Application no: H11/0480/99

Description: Landscaping, revised access
arrangements and erection of a
sign canopy for existing car
park

Location: Market Place
Long Sutton
Spalding
Lincs

Amendment: Delete roof detail from signage housing.

Date	JANUARY 1999	Scale	1:50	1:20
Drawing No.	1484:98:6		A	B

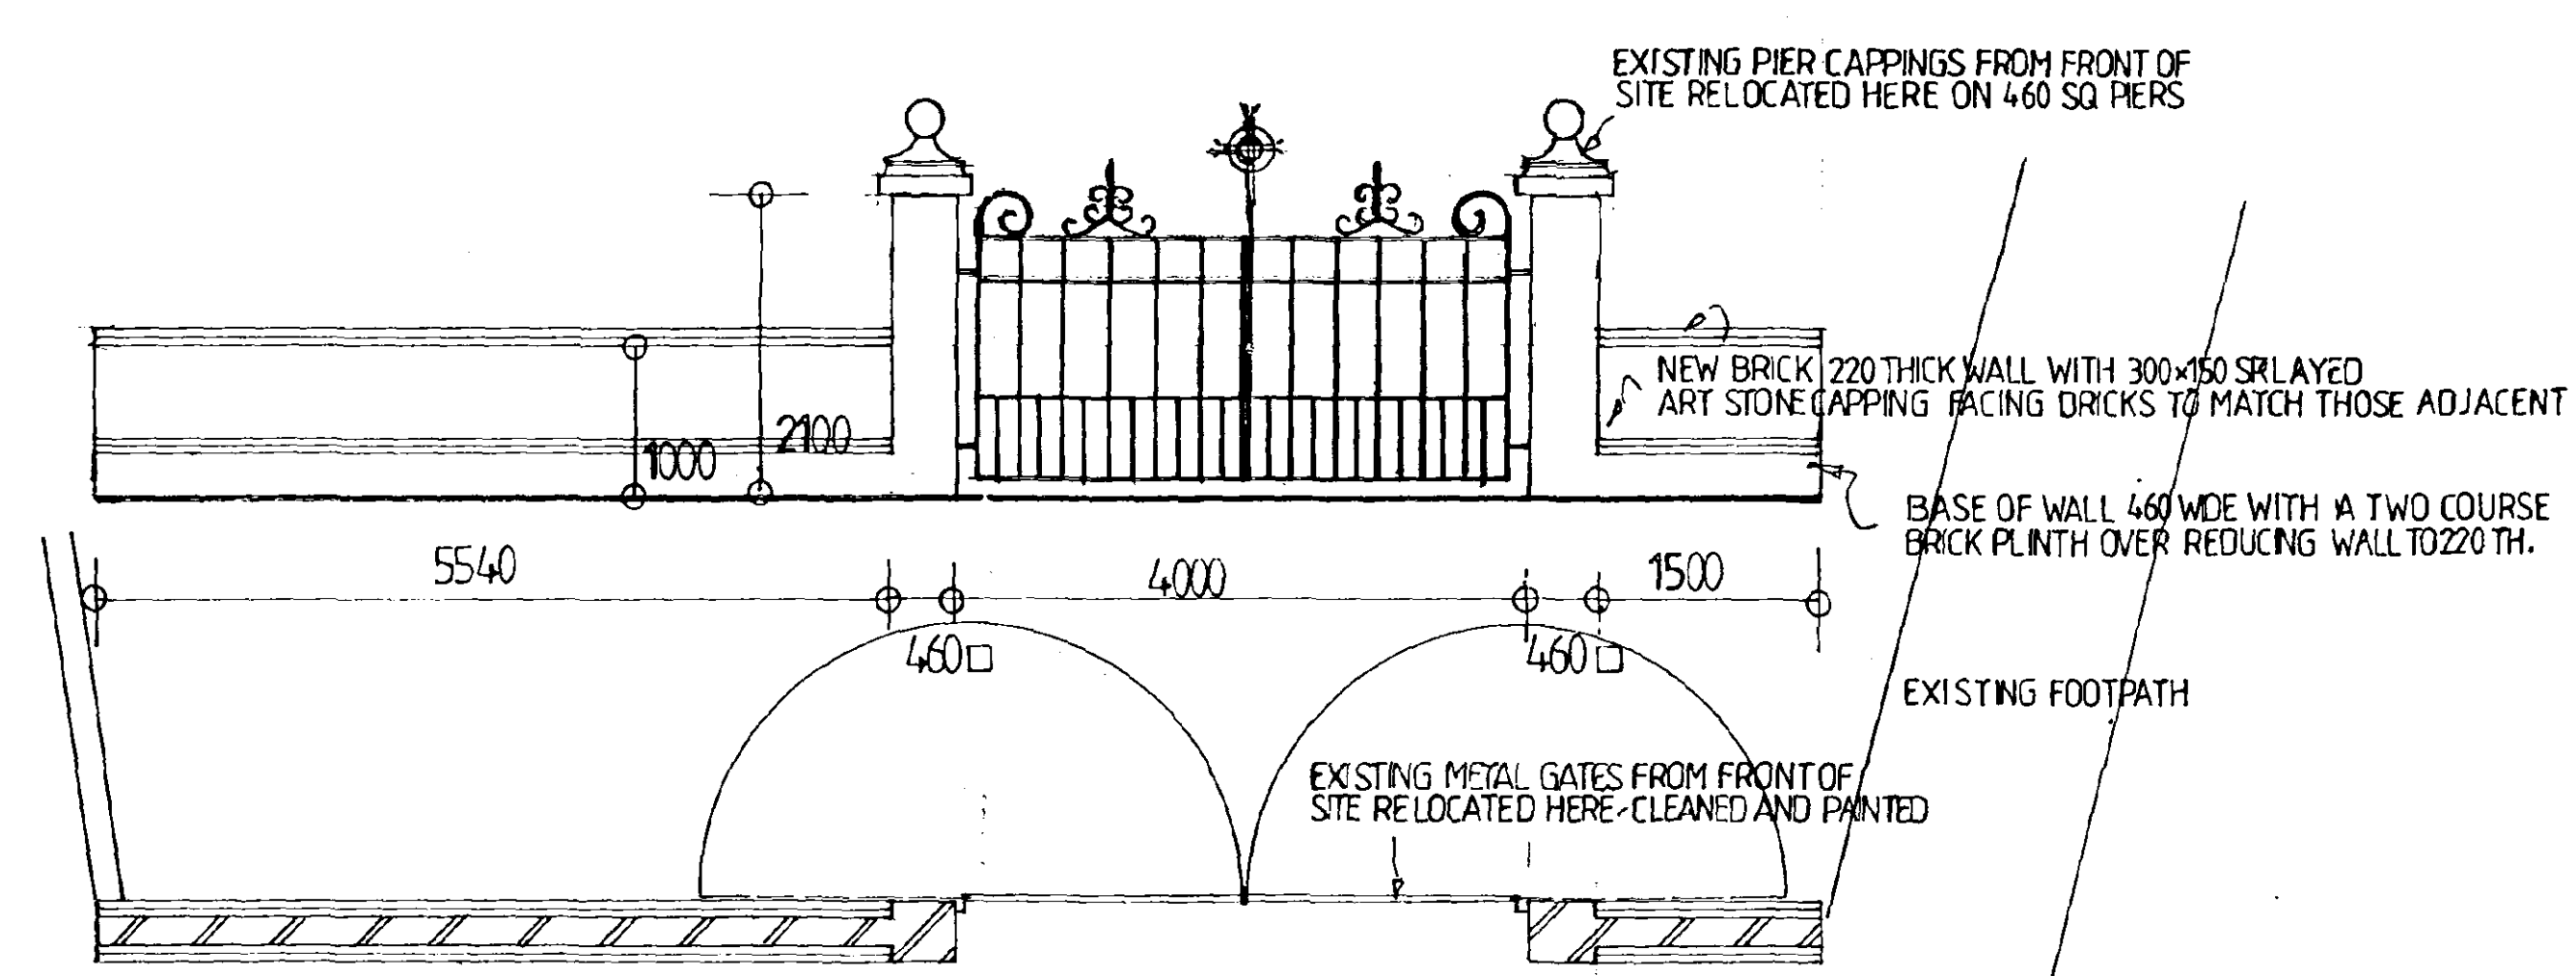
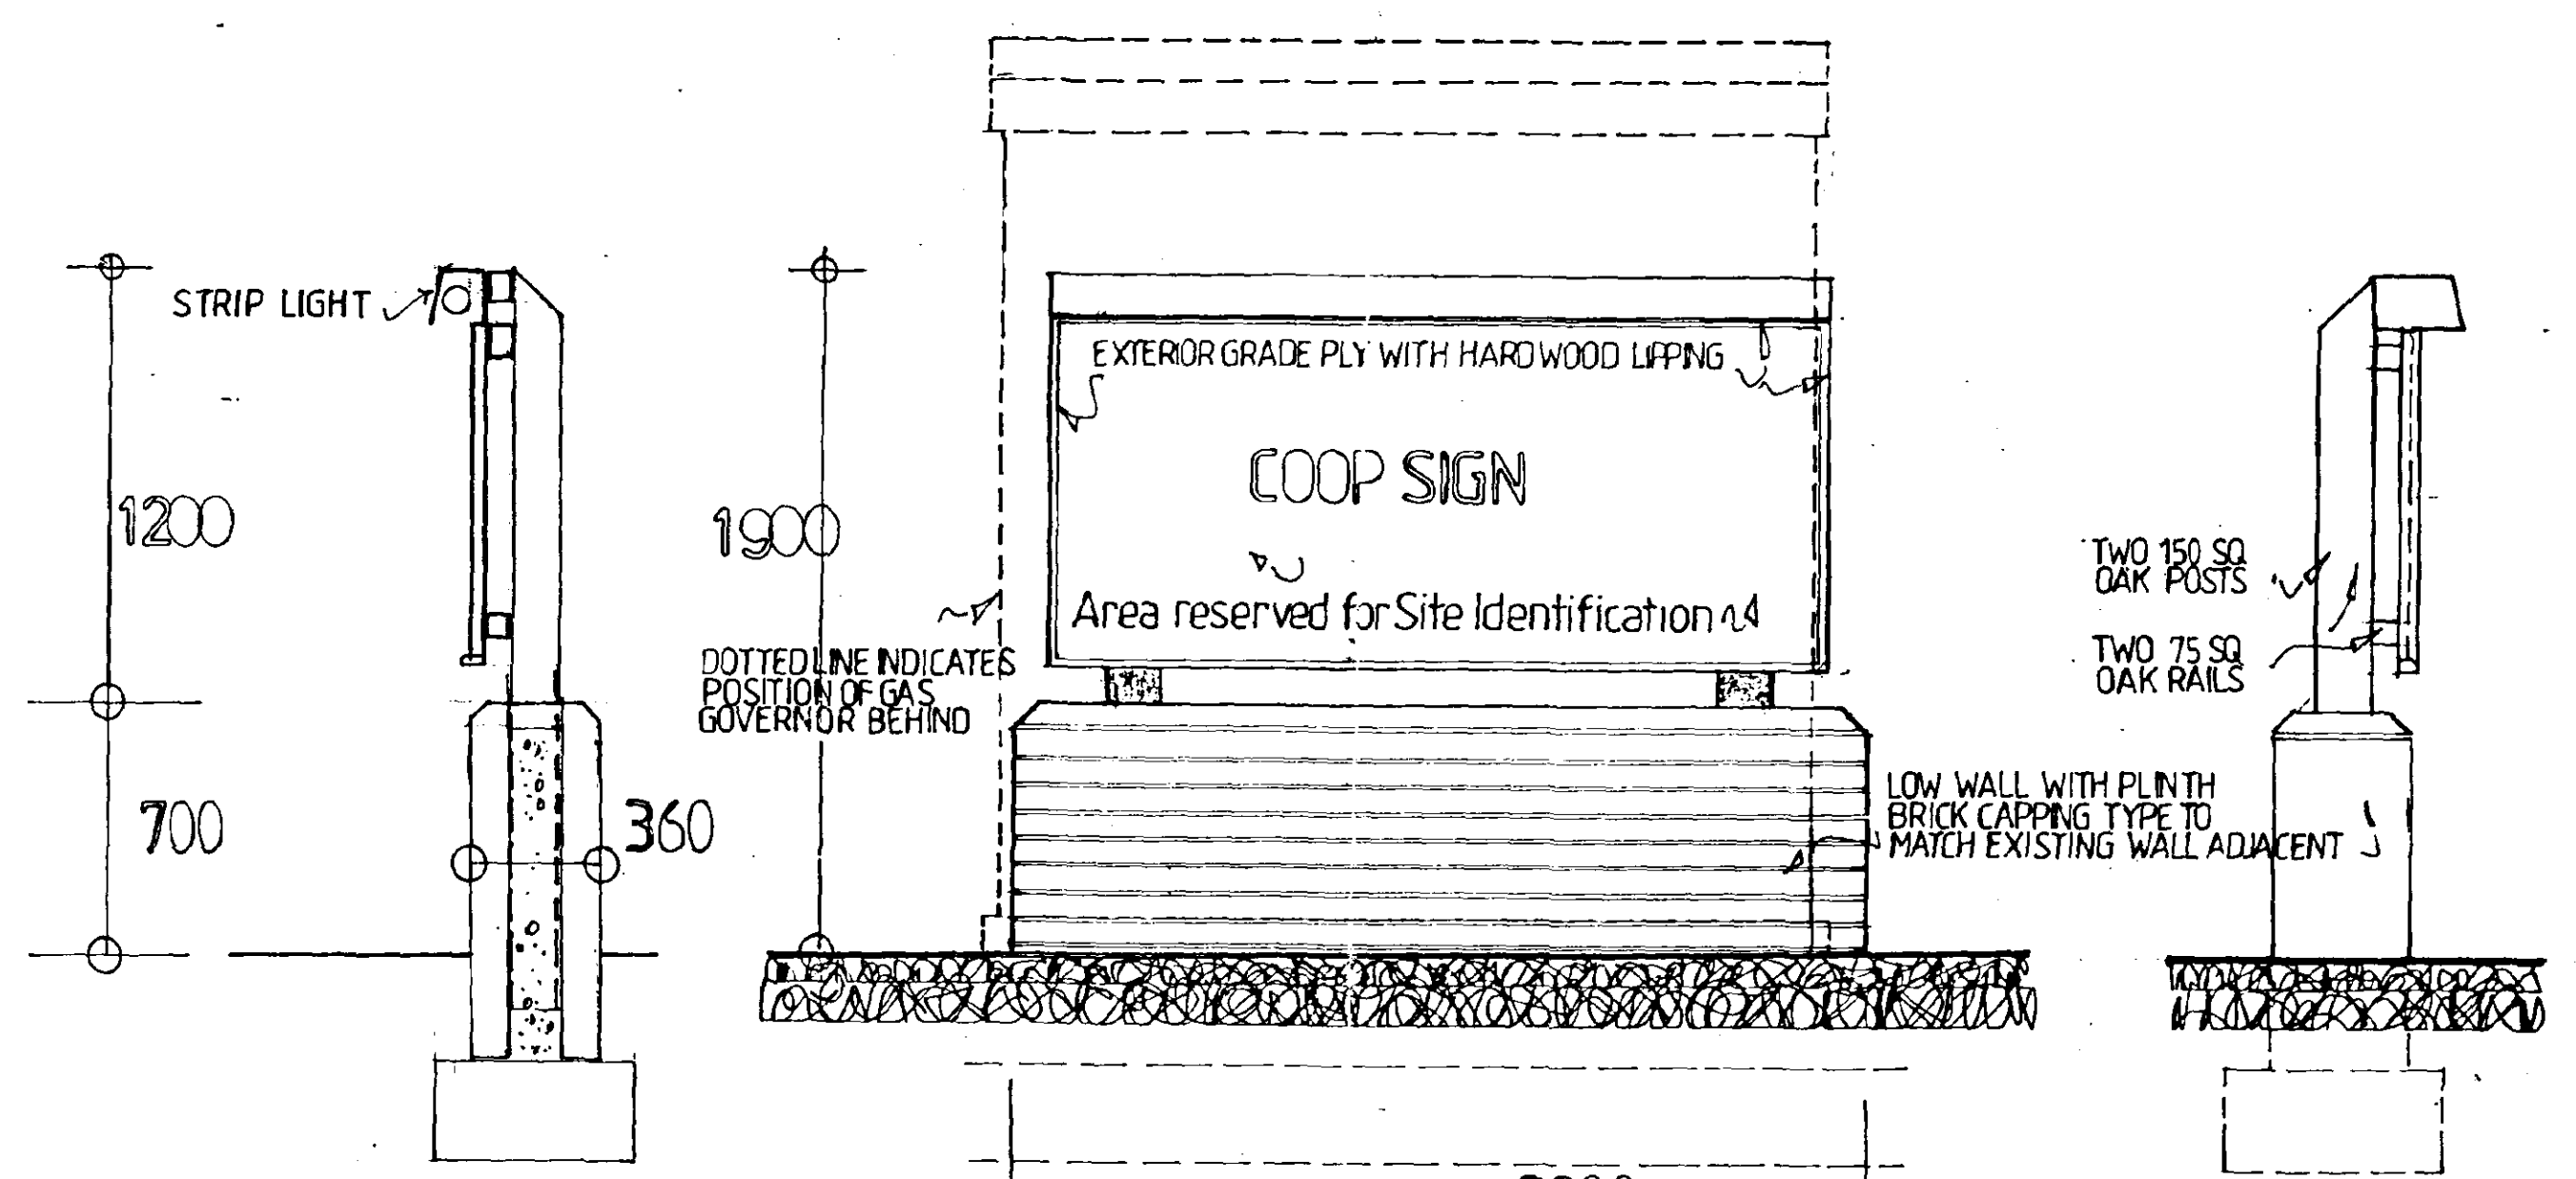
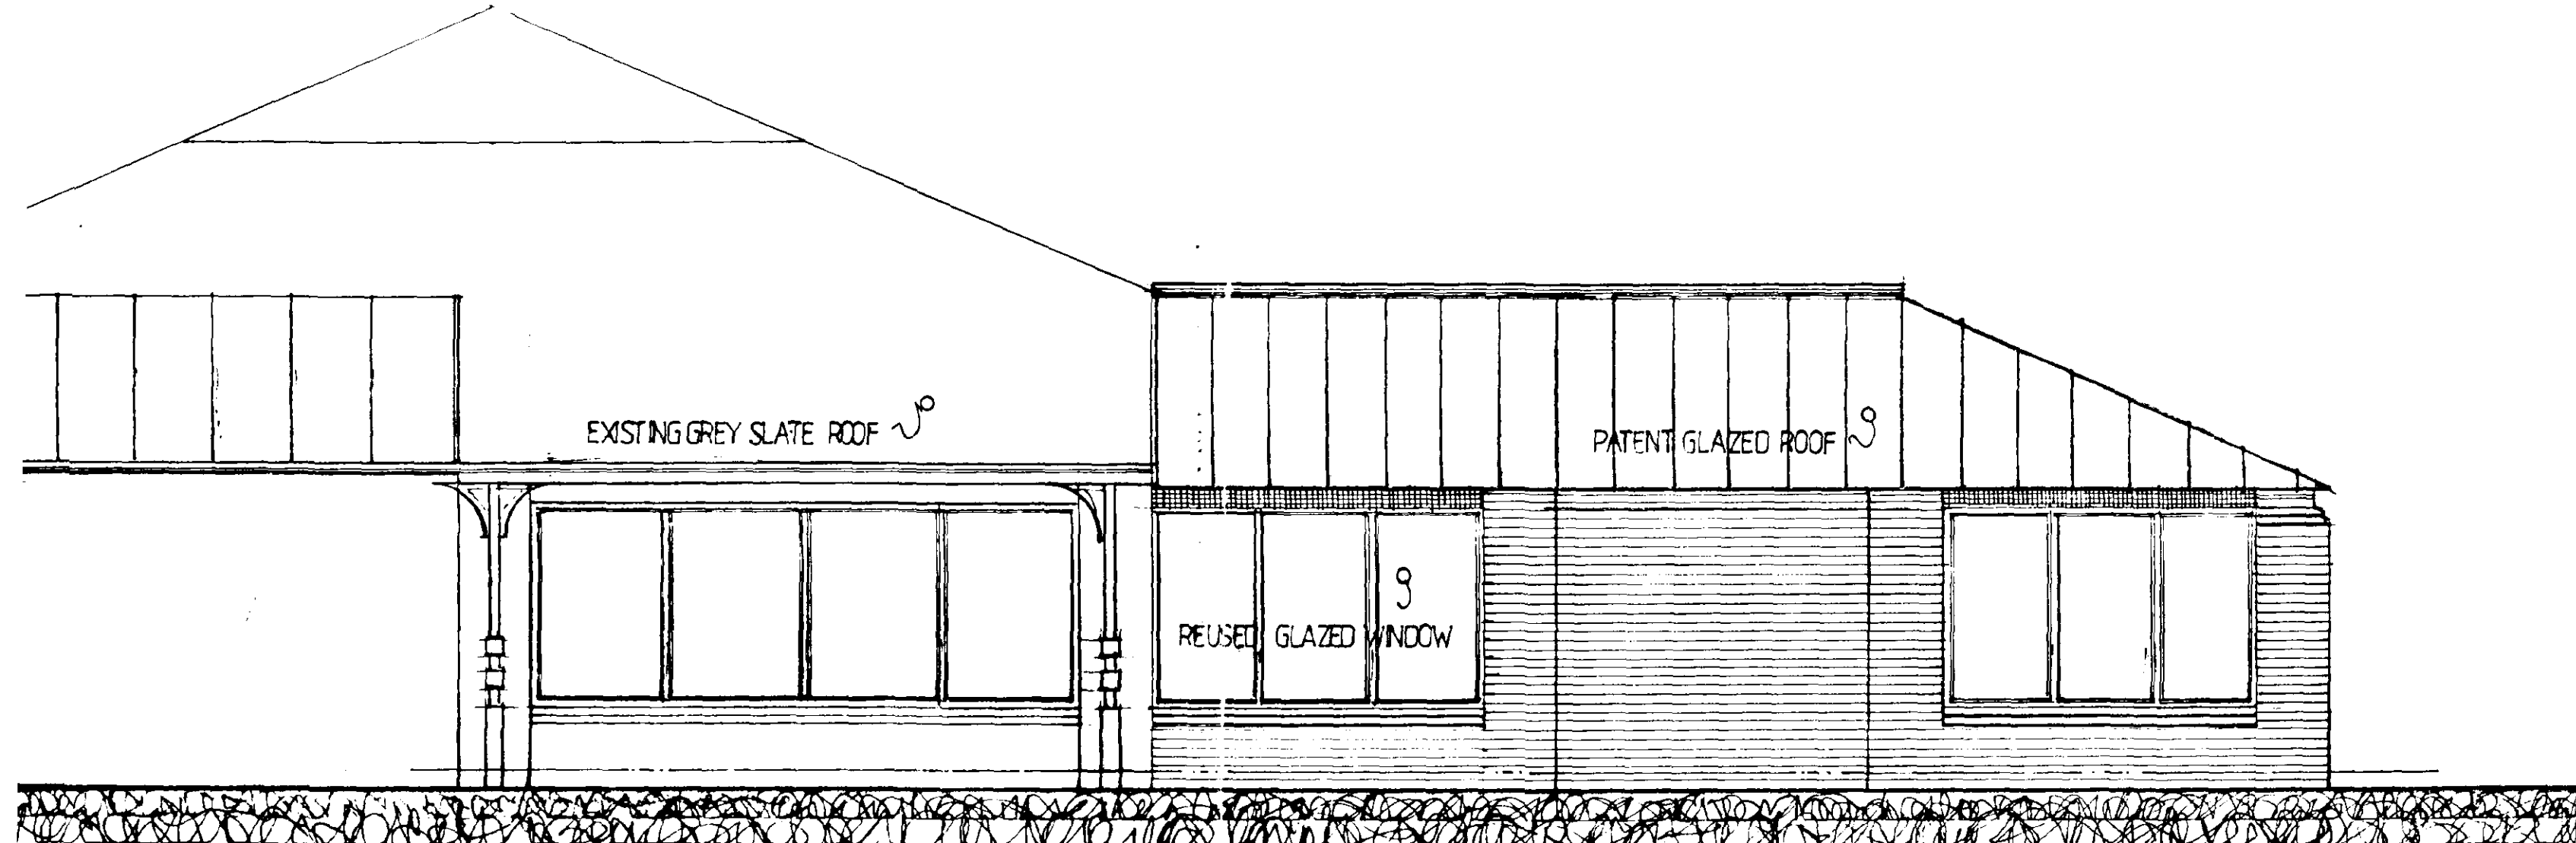
Removal of roof
from sign
Delete roof detail from
signature housing.
